PREPARED 7/26/07, 14:01:00  
Harnett County

INSPECTION TICKET  
INSPECTOR: IVR

-----  
ADDRESS . . : 111 SONORA DR  
CONTRACTOR : H & H CONSTRUCTORS INC  
OWNER . . . : H & H CONSTRUCTORS INC #156  
PARCEL . . . : 01-0536-04- -0028- -55-  
APPL NUMBER: 07-50017655 CP NEW RESIDENTIAL (SFD)  
DIRECTIONS : HWY 27 W TO NURSERY RD TURN LEFT ON  
NURSERY LEFT ON LEMUEL BLACK RD LEFT ON  
WOODSHIRE DR LOT 156 JB  
-----

PERMIT: CPSF 00 CP \* SFD

SURVEY FOR:  
**PROPOSED PLOT PLAN - LOT - 156**

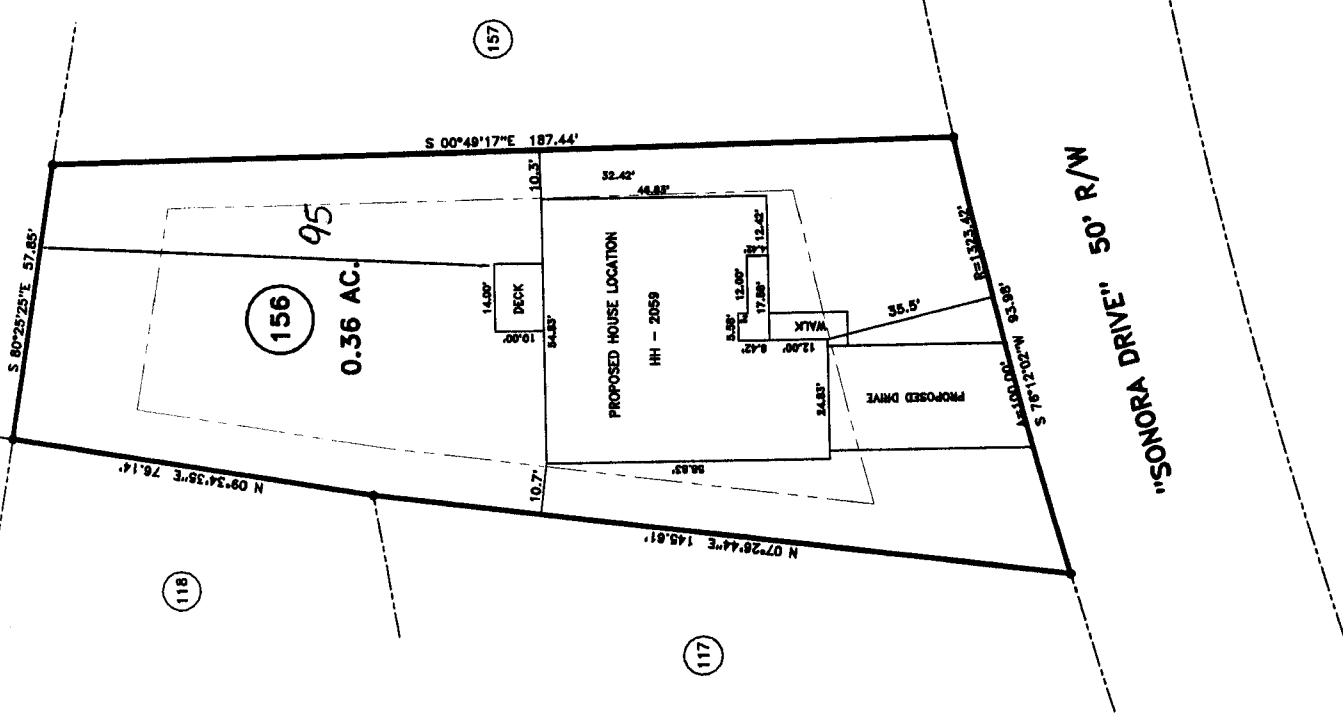
TYP/SQ	REQUESTED COMPLETED	INSP RESULT	DESCRIPTION RESULTS/COMMENTS
B101 01	7/27/07 7/27/07	DT DA	R*BLDG FOOTING / TEMP SVC POLE VRU #: 001455008 Footing dug 18 feet from existing house next store. Must have survey done to check 10 foot side setback.
B101 02	8/02/07 <u>8/2/07</u>	TI <u>AP DT</u>	R*BLDG FOOTING / TEMP SVC POLE VRU #: 001458826
